**Albuquerque Studios Master Plan
Development**

Traffic Impact Study

January 4, 2022

The following two sections in the Executive Summary list agency comments received on the draft TIS submission along with responses provided for this final TIS.

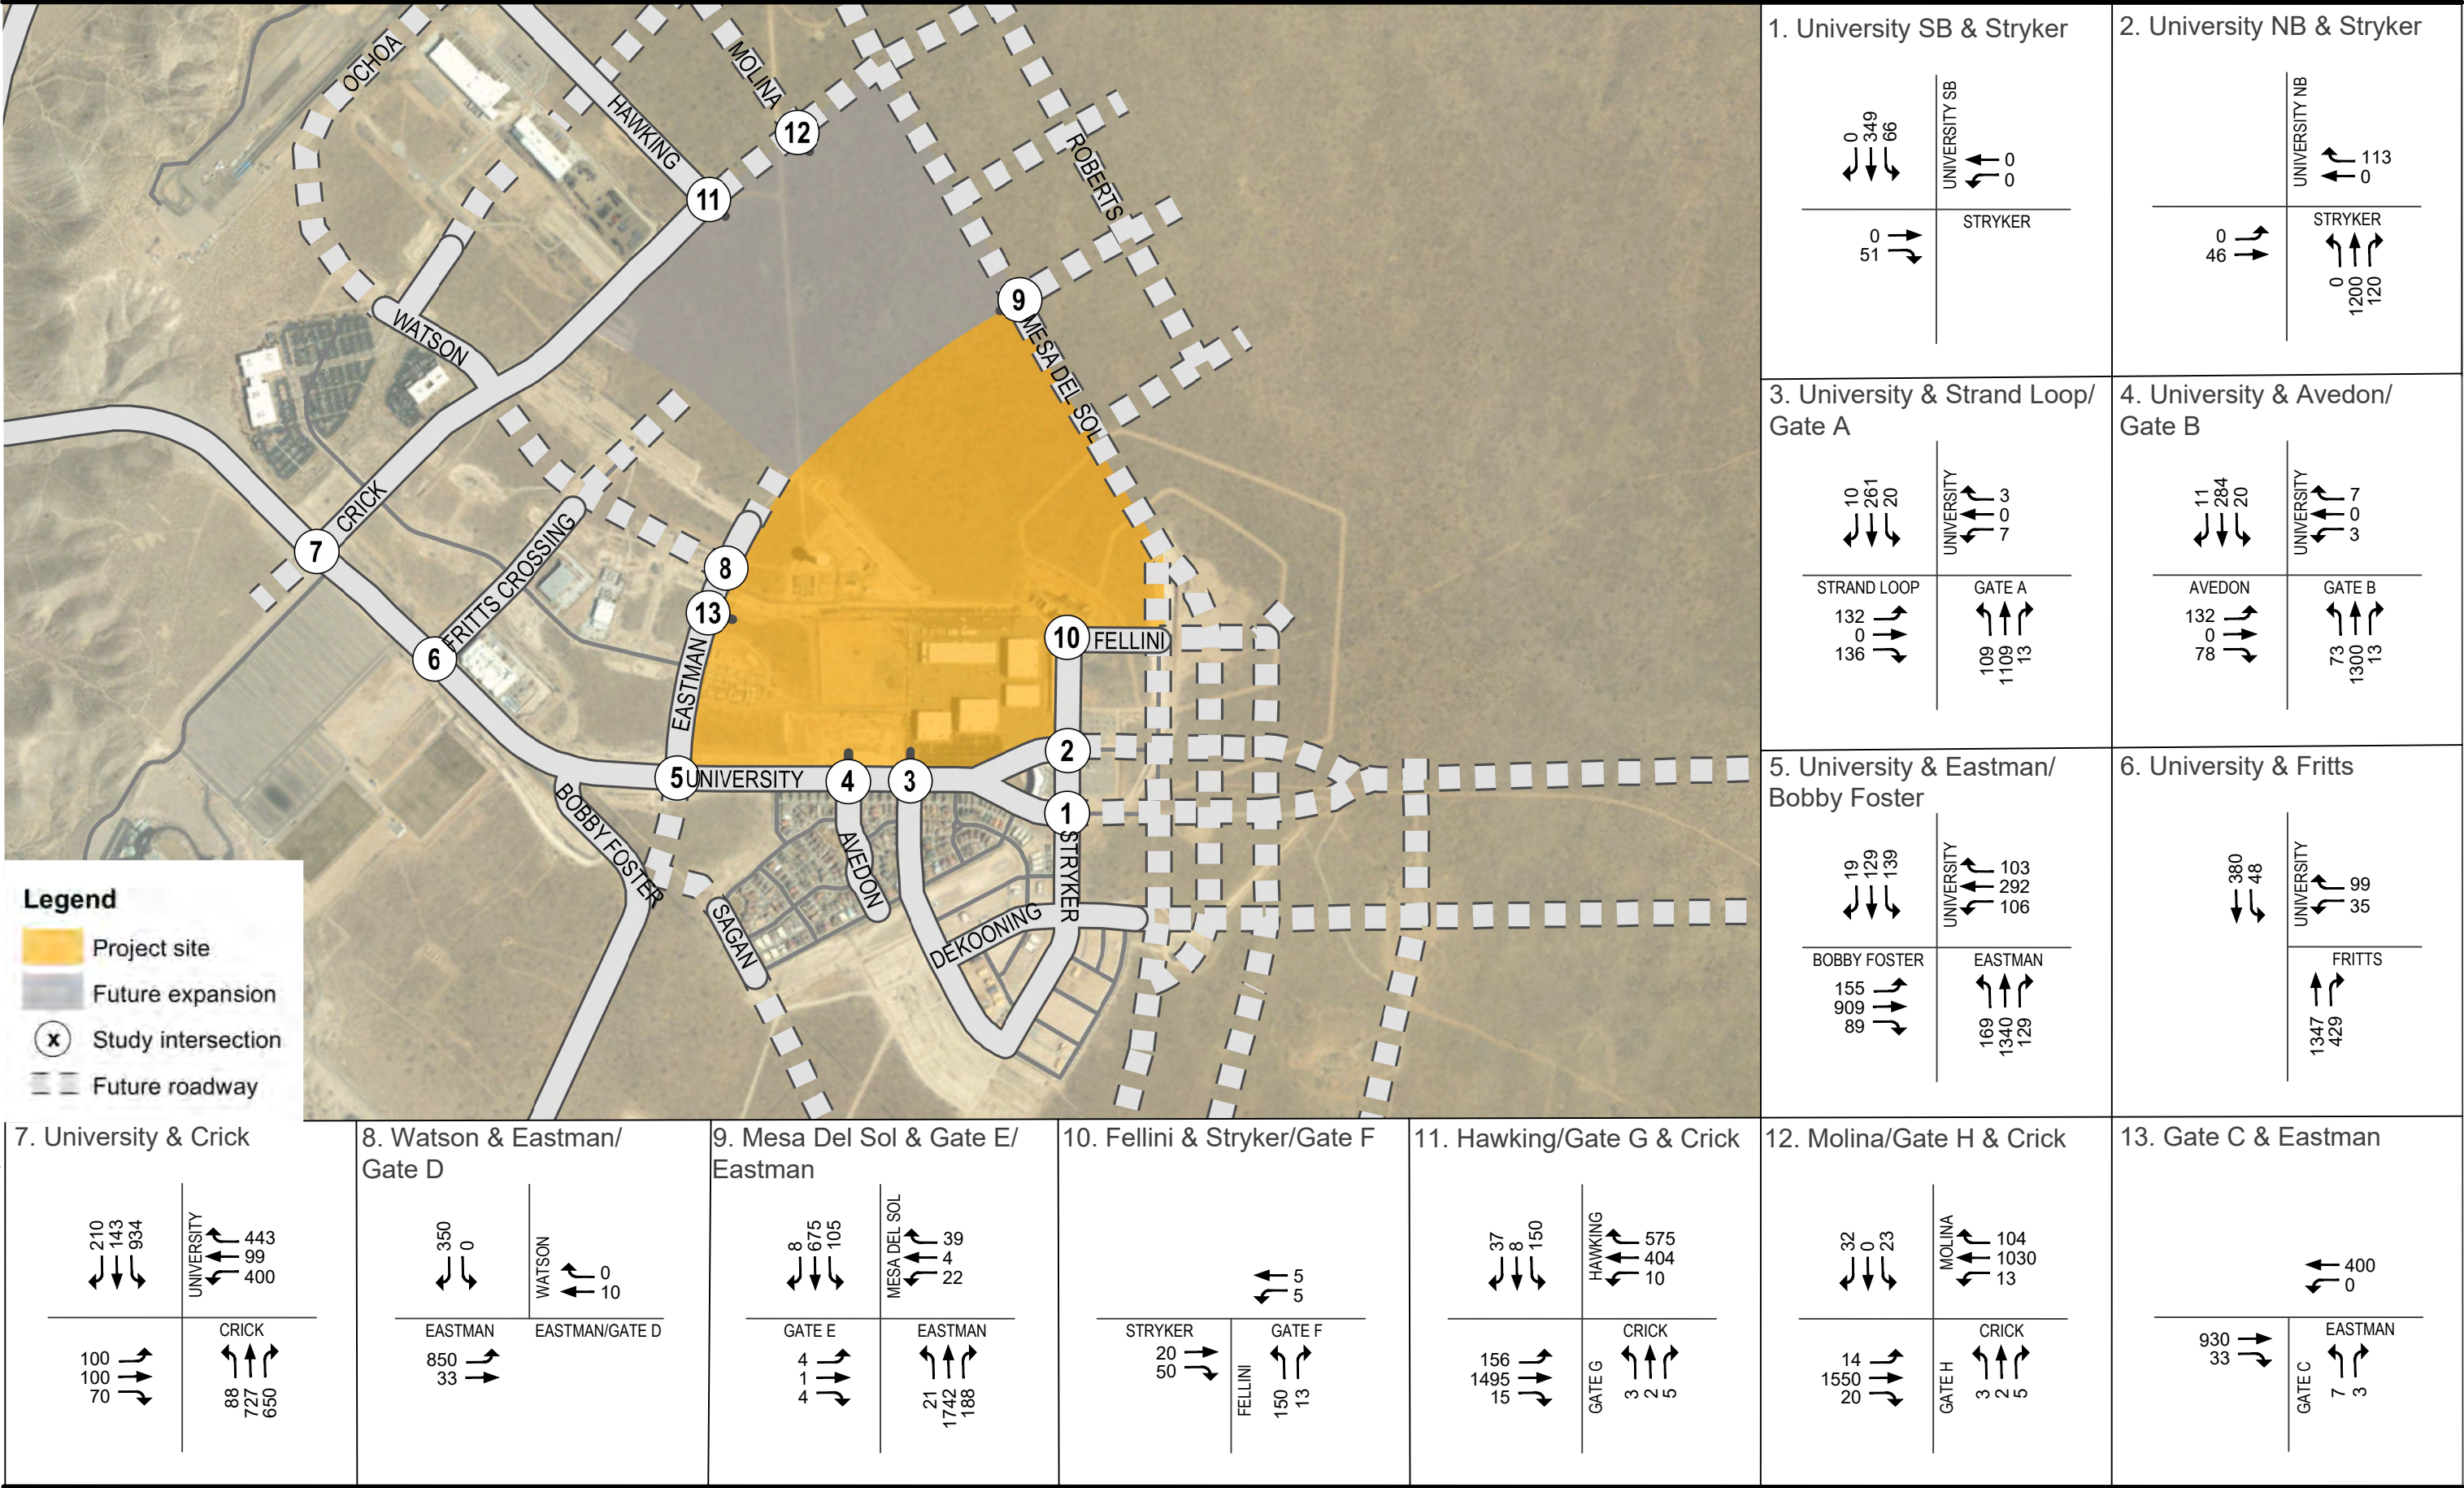
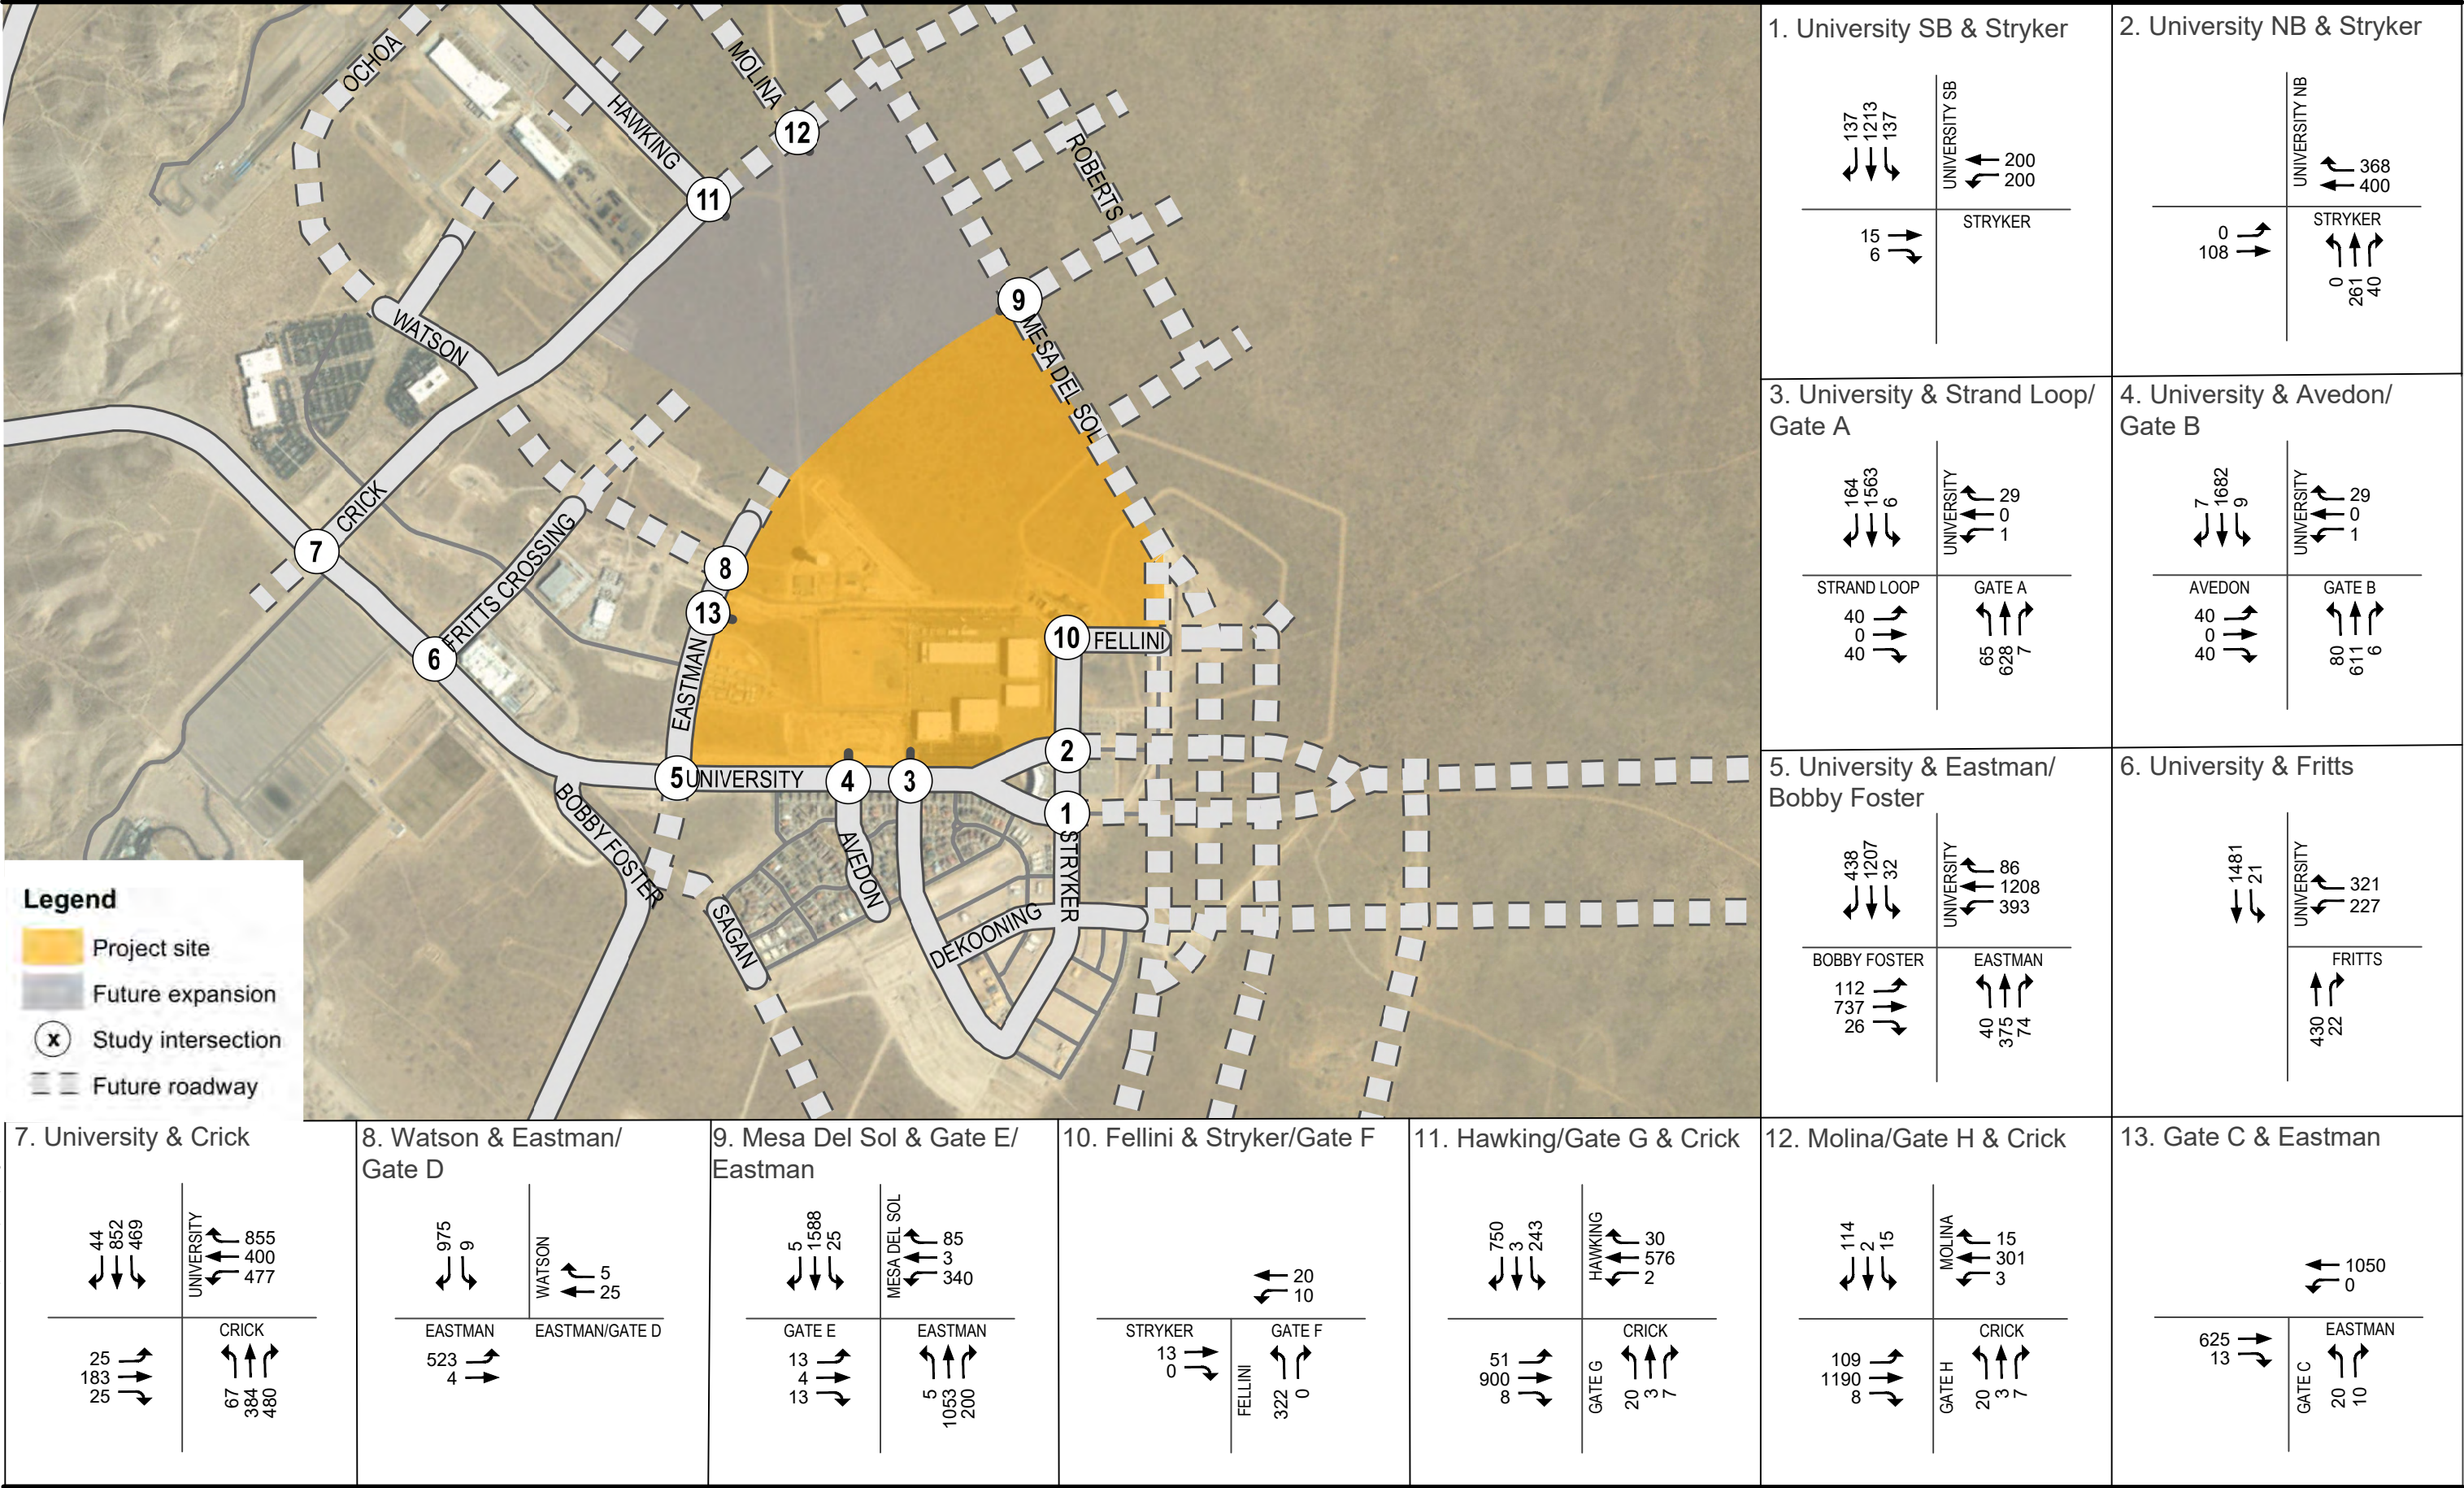
Intersection 10 Hawking/Fellini/Stryker: Determine where the traffic is coming from and who is responsible?

- 
- Stryker EB right to SB Fellini - (Bypass Traffic - not Netflix Traffic) – to incorporate a left turn lane
 - Fellini NB left to Stryker - (Netflix Traffic) – to incorporate a right-turn lane
 - Provide cross sections to show constraints that need to be resolved to increase the street width as needed

Intersection 10 Hawking/Fellini/Stryker:

- Stryker EB right to SB Fellini - (Bypass Traffic - not Netflix Traffic) – not feasible due to section constraints
- Fellini NB left to Stryker - (Netflix Traffic) – not feasible due to section constraints
